TOWN OF MONUMENT - WATERLINE AND STORAGE TANK
 SITE DEVELOPMENT PLANS
 LOT 6, FOREST VIEW ESTATES FILING NO. 4

2.0 MG WATER STORAGE TANK

90% SUBMITTAL

TANK PROFILE
SCALE: 1" = 10'

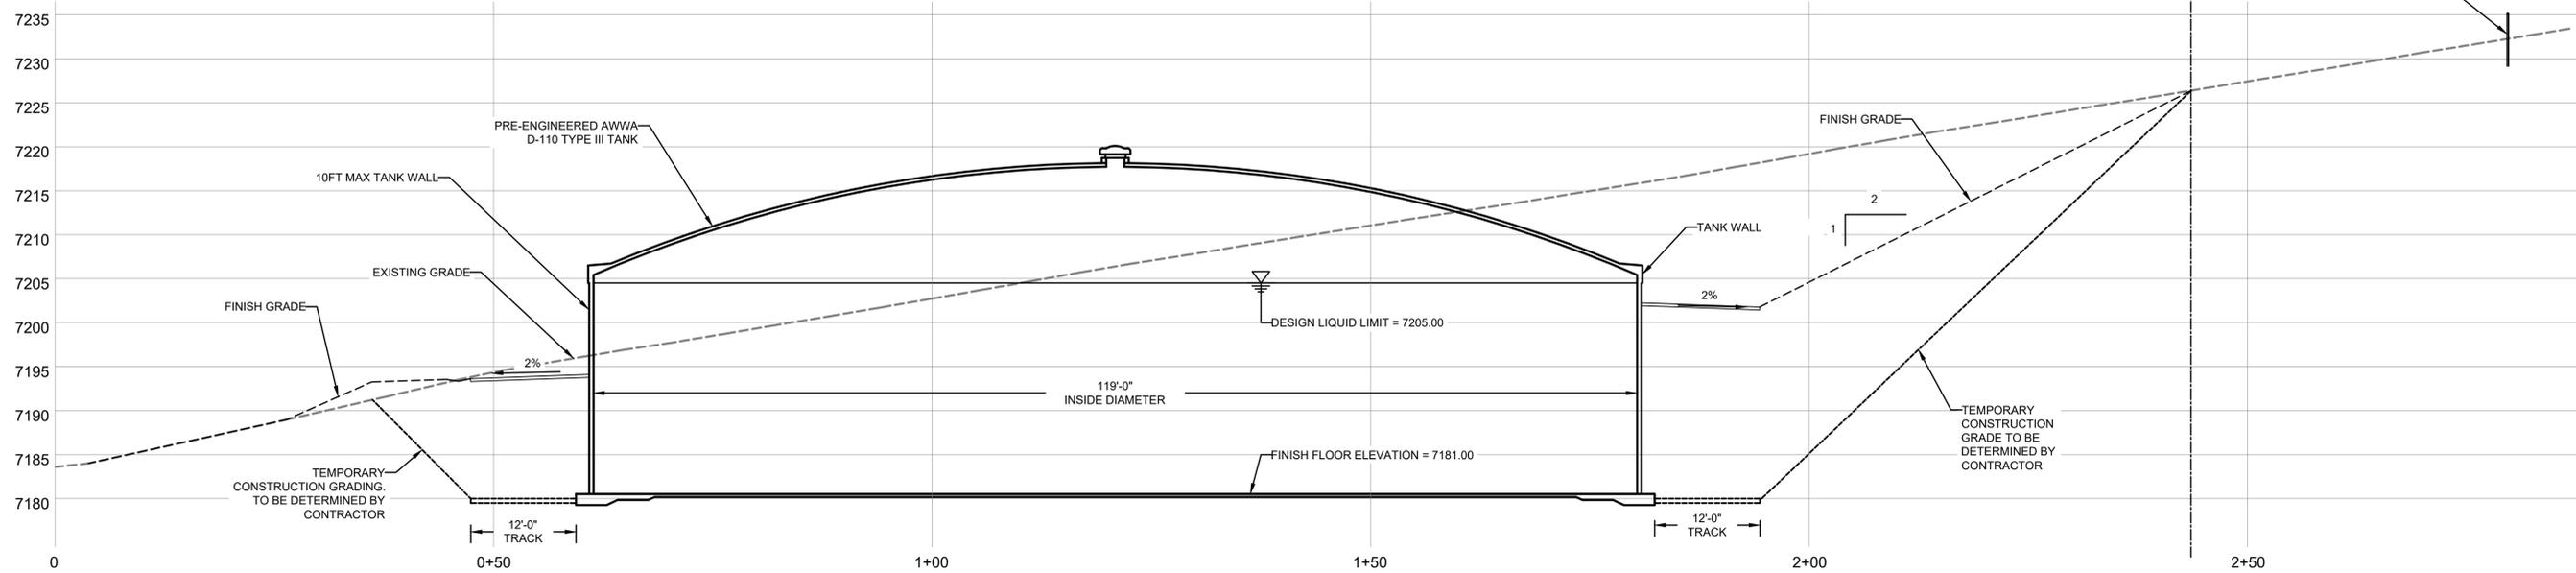
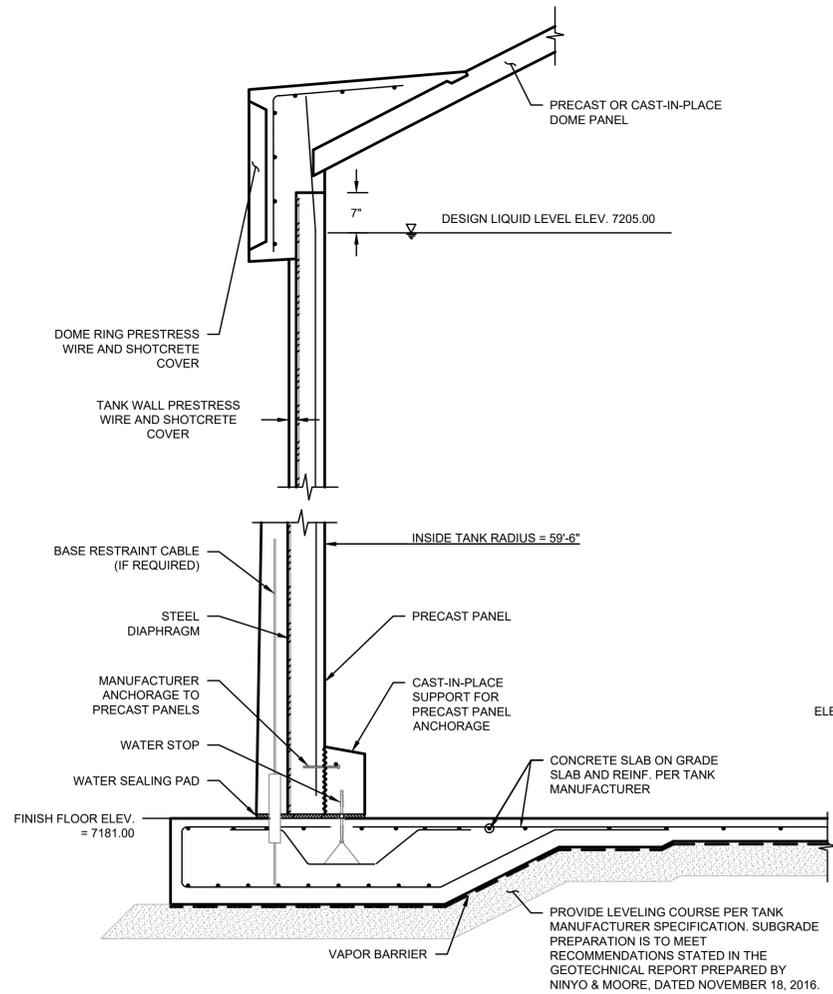
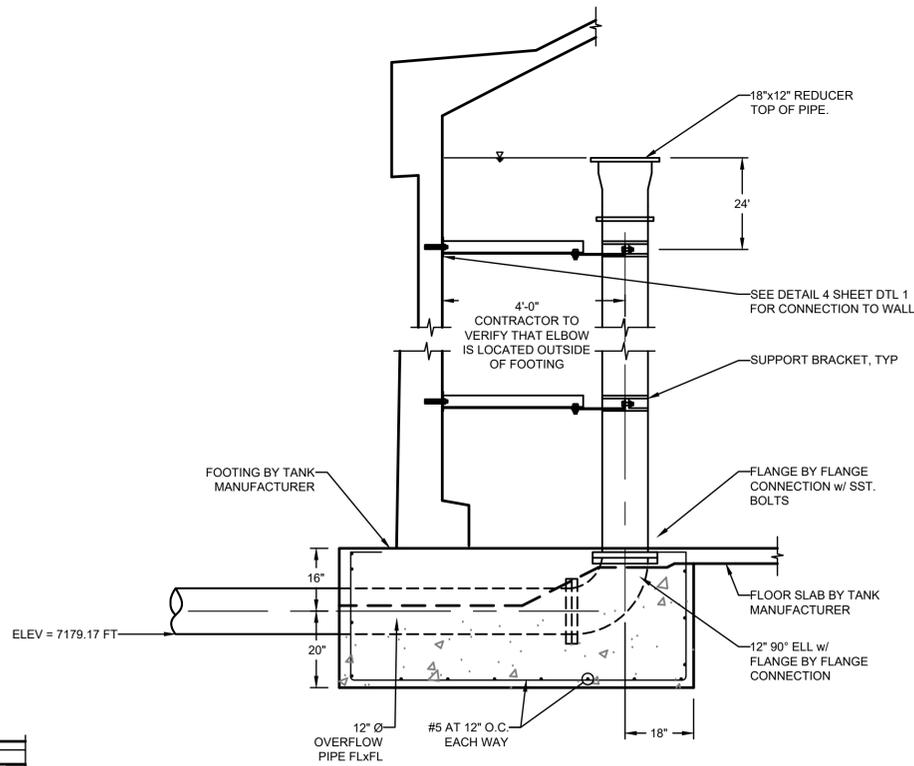
Add circumference and total gallon storage

LIGHT POLE FOUNDATION DETAIL

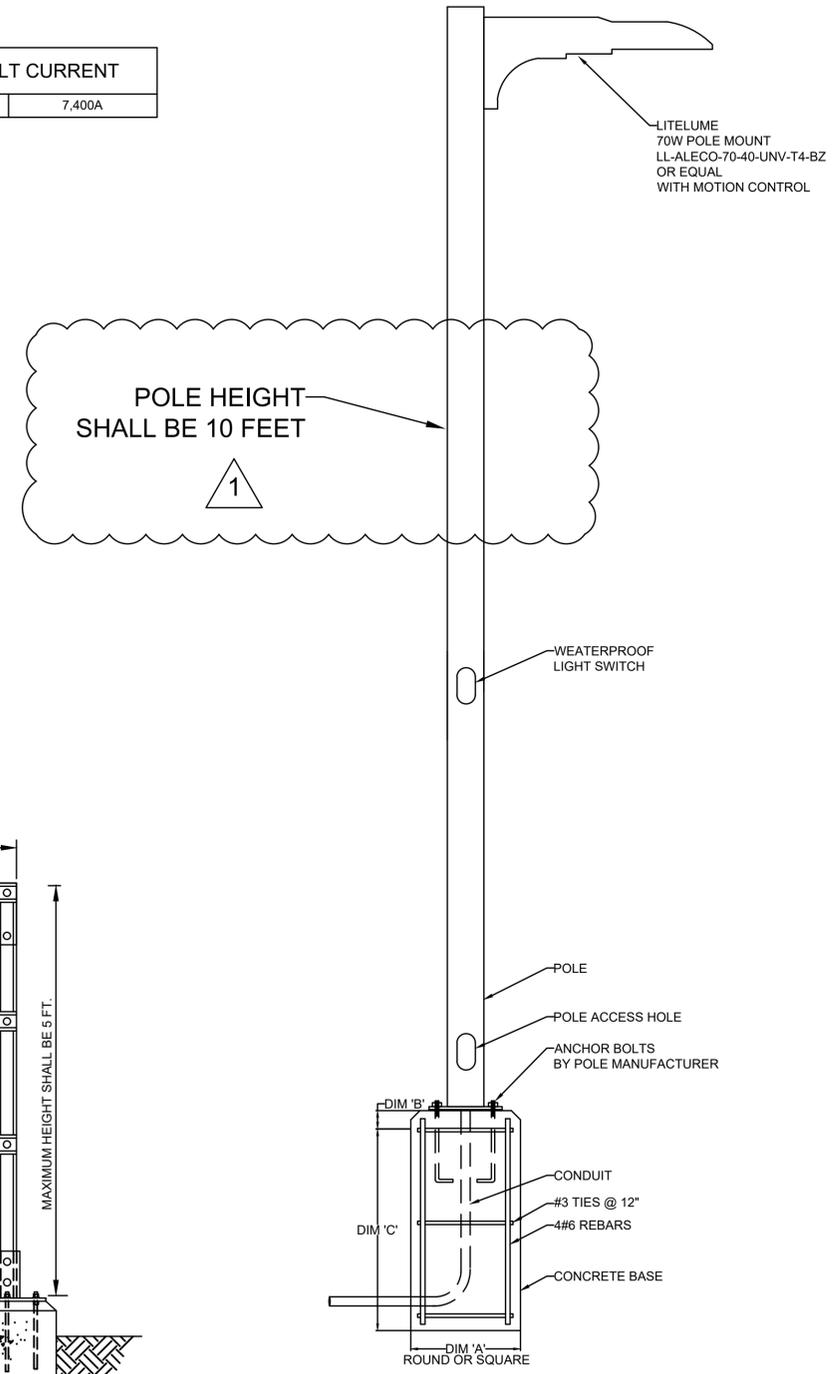
Add note that lumens will not exceed Max (based on Code)

is there only one light on entire project? If not add locations and detail of fixture

This exceeds the lighting standards; revise per Code above (Chapter 6). Please provide the exact detail for the fixture and pole- This is very industrial in nature; this is a residential zone district;

TANK SITE PLAN
SCALE: 1"= 20'

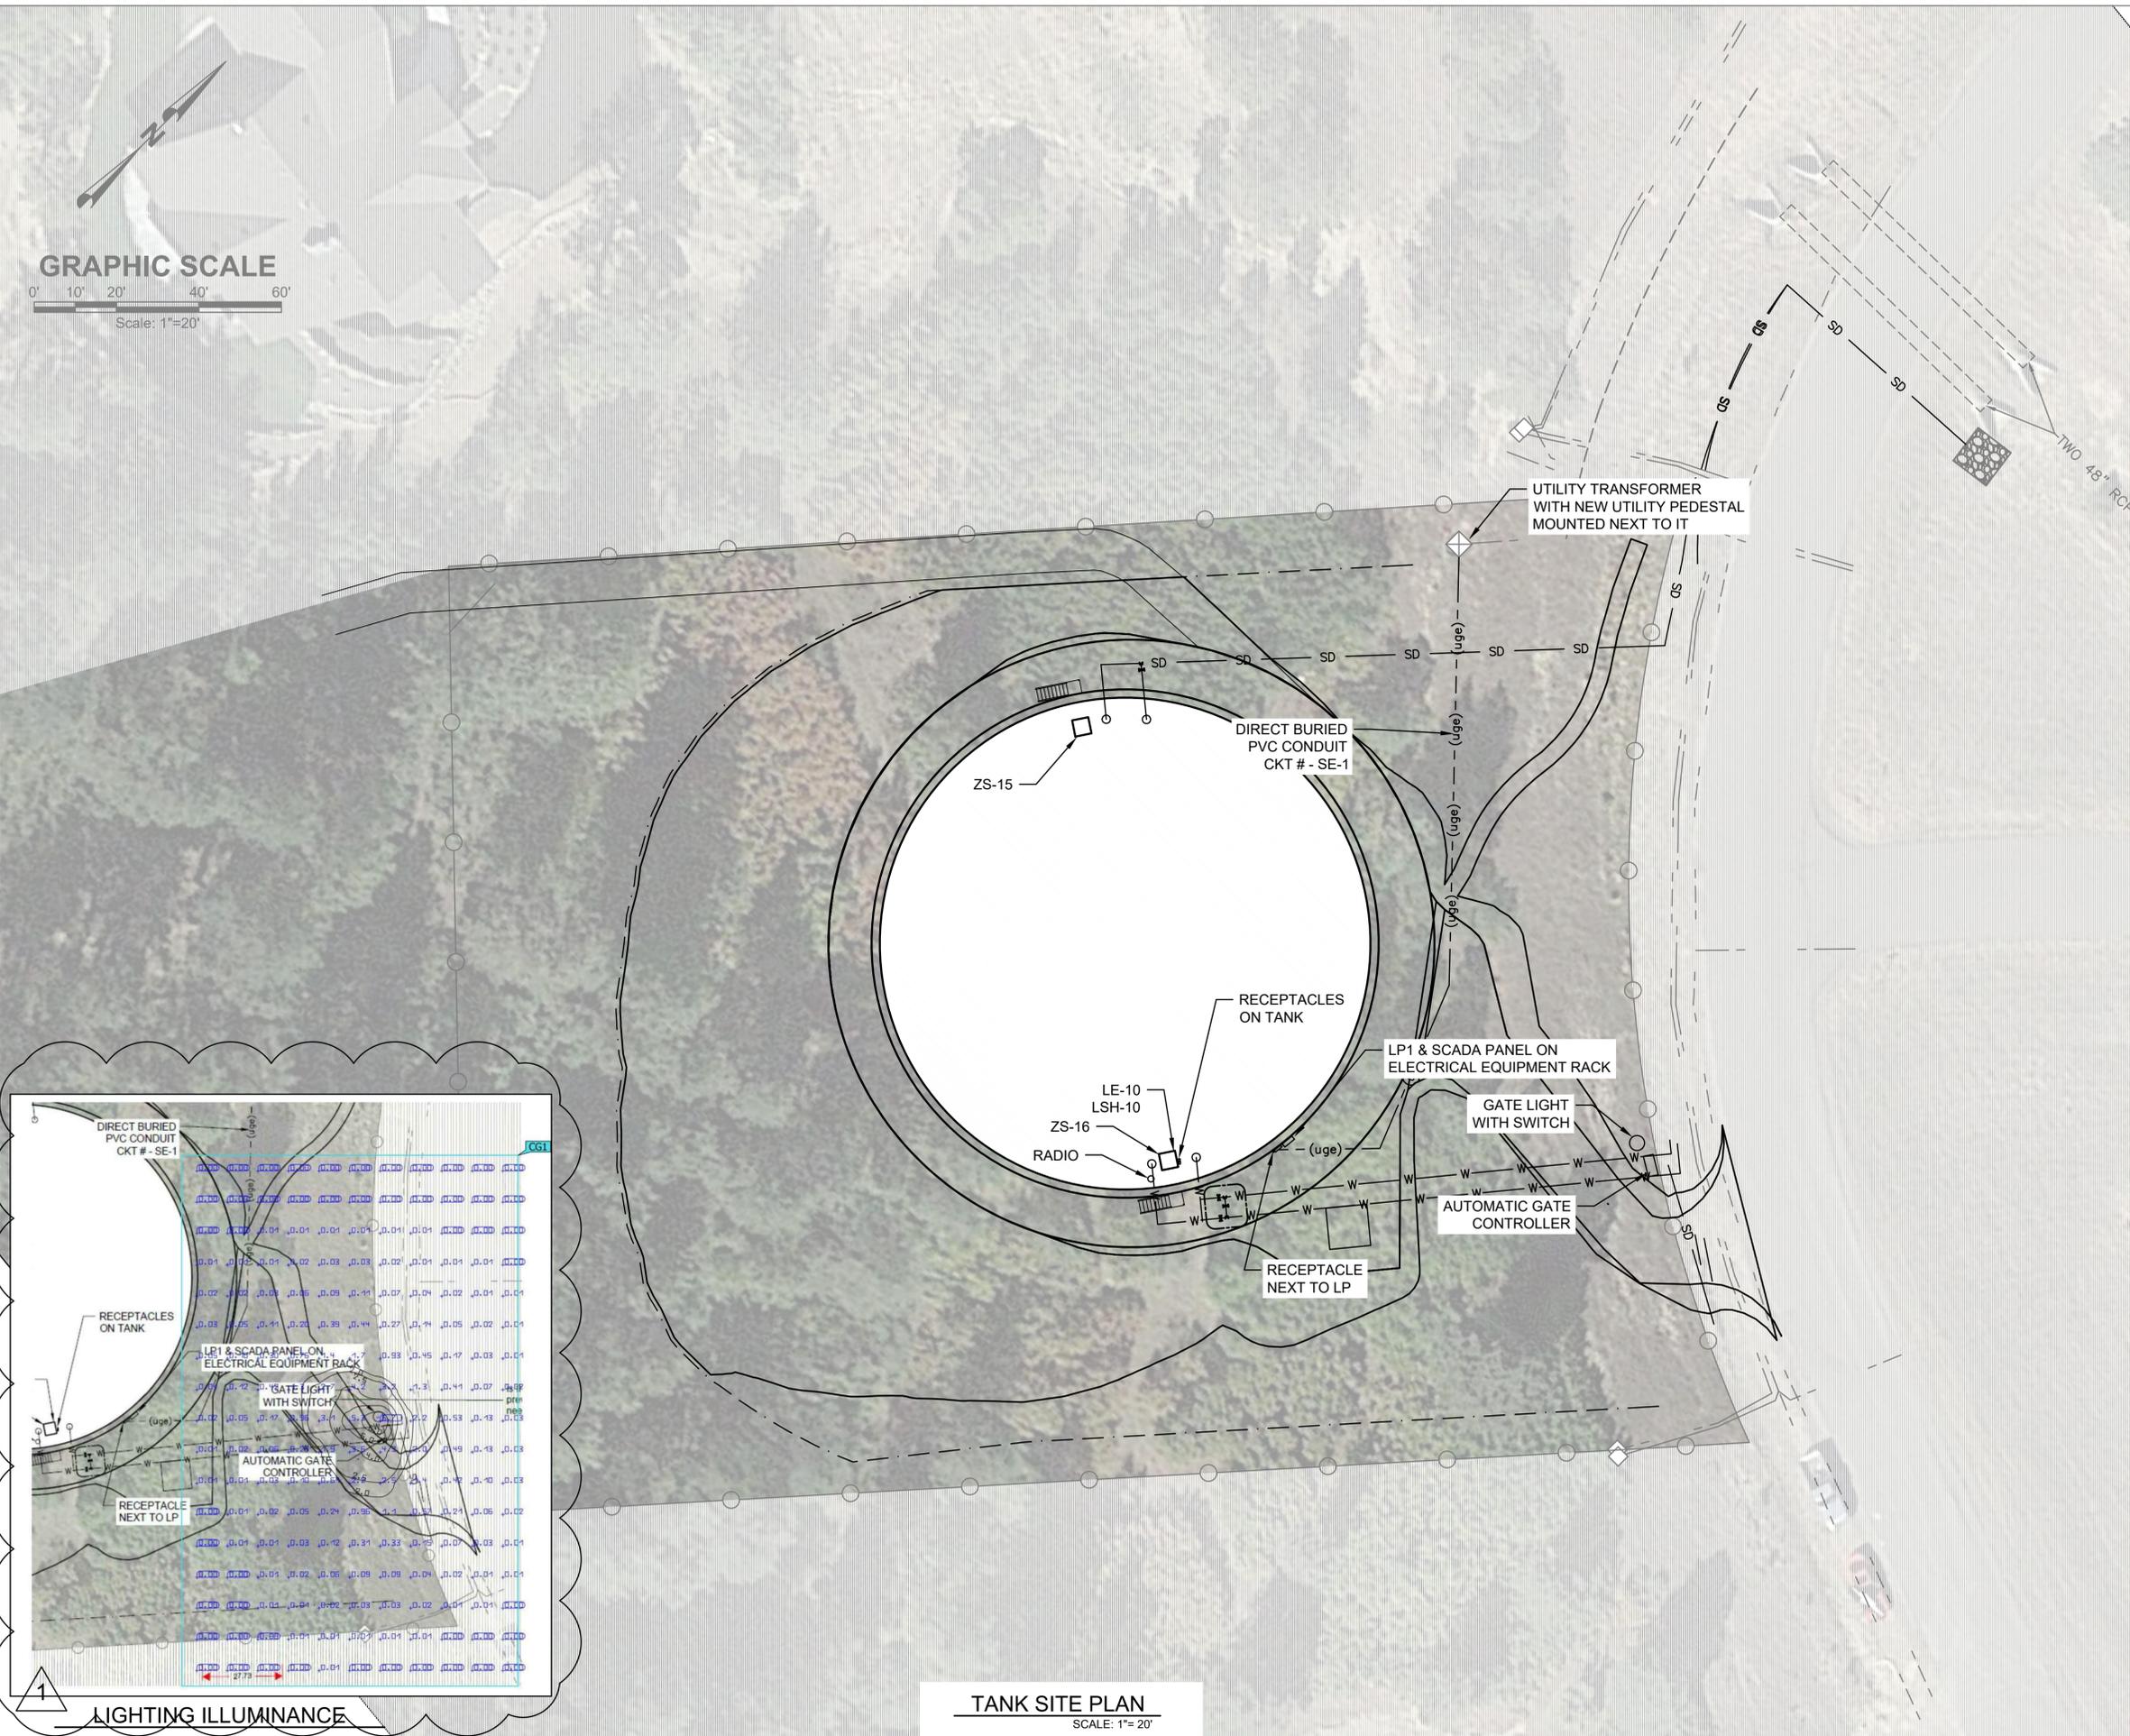
Not provided on GEC Plan- Label the width and surface; if the driveway apron connects to pavement, it needs to be labeled as pavement or concrete hard surface on this sheet and on landscape plans

Add dimensions of chlorine bldg and future landing site

Label the radius and height of tank. Height above ground is

Add the dimensions from tank to each property line

asphalt paved driveway with a culvert under it is required, and a commercial driveway permit. the width can be between 25'-40'
